Date: 6/3/2020

Project Name: Mark Champion

Address: 11454 Highway 210 North

DRAWING BY Cameron Lawson	
DATE March 12, 2020	
PROJECT NUMBER 75089684	
SHEET NAME ELEC. 3 LINE DIAG.	
PAGE NUMBER PV5	REVISION ----

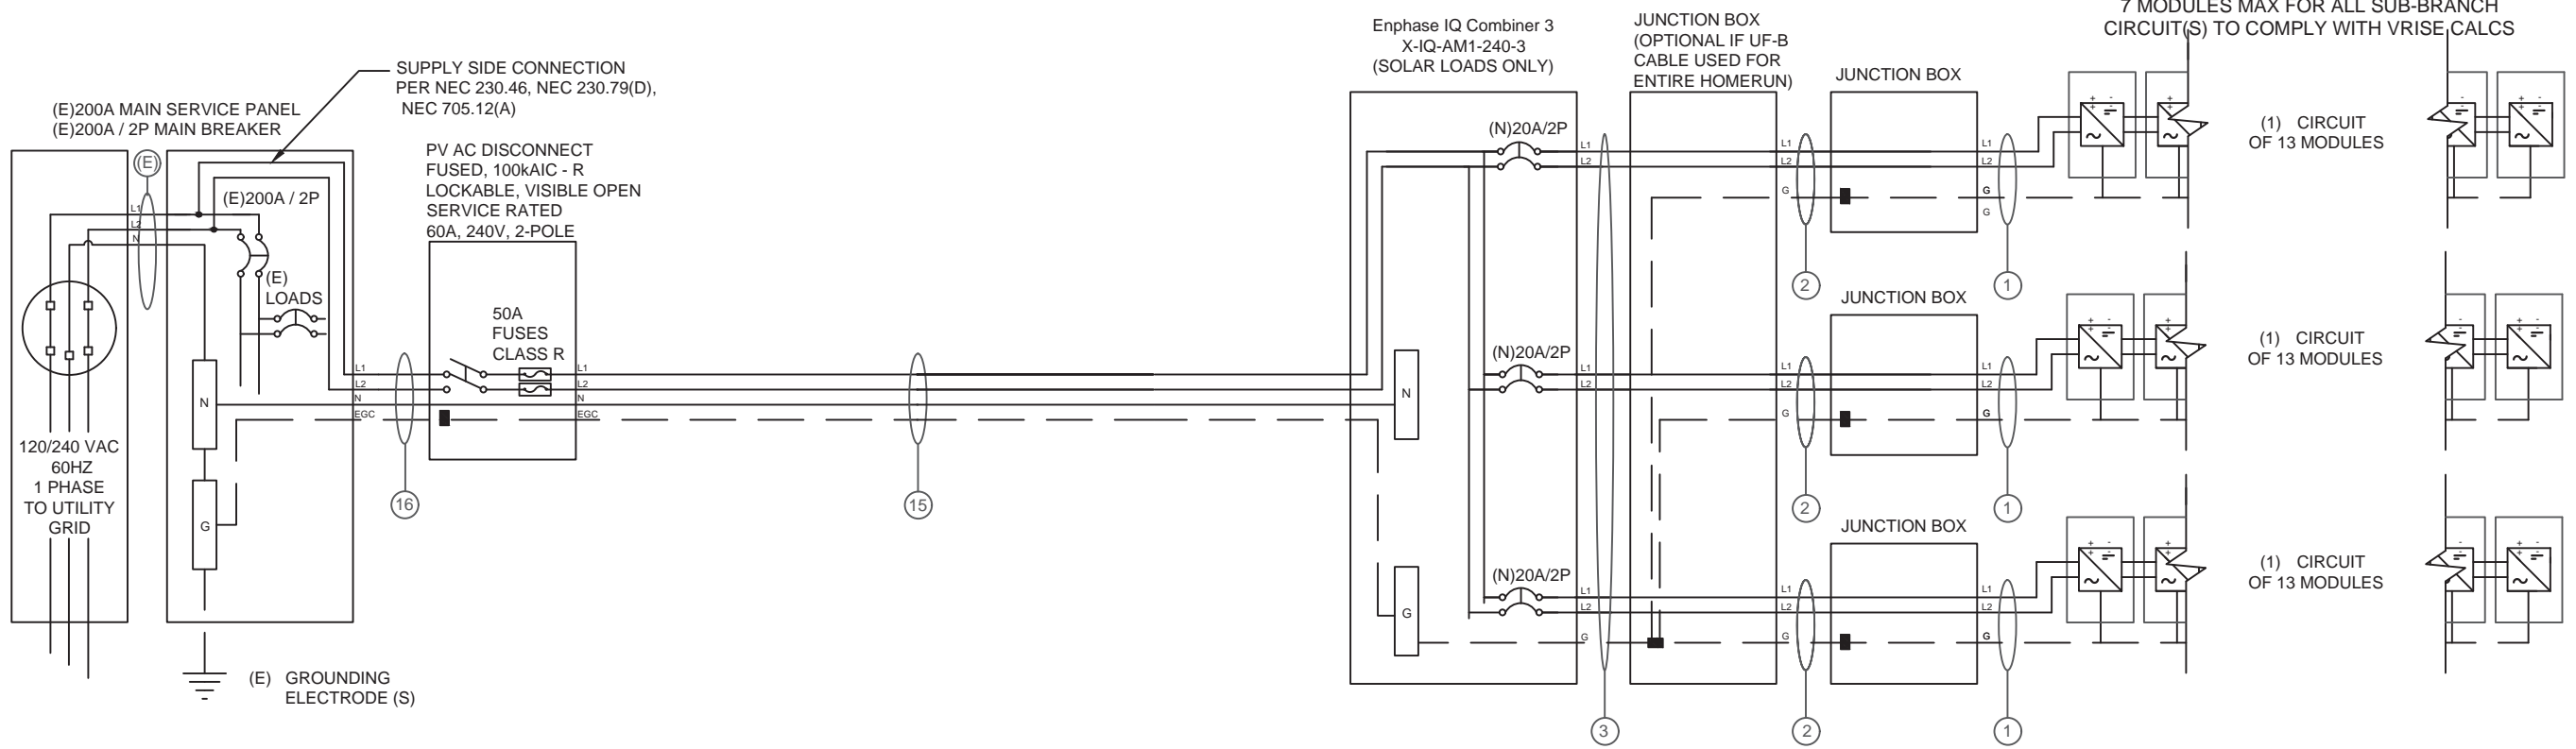
Please update the tie-in method with the dropdown "Supply-side tap - CO Springs". Make sure the wire tags are also updated to reflect a #8 or larger neutral, and no ground in between the MSP and disconnect.
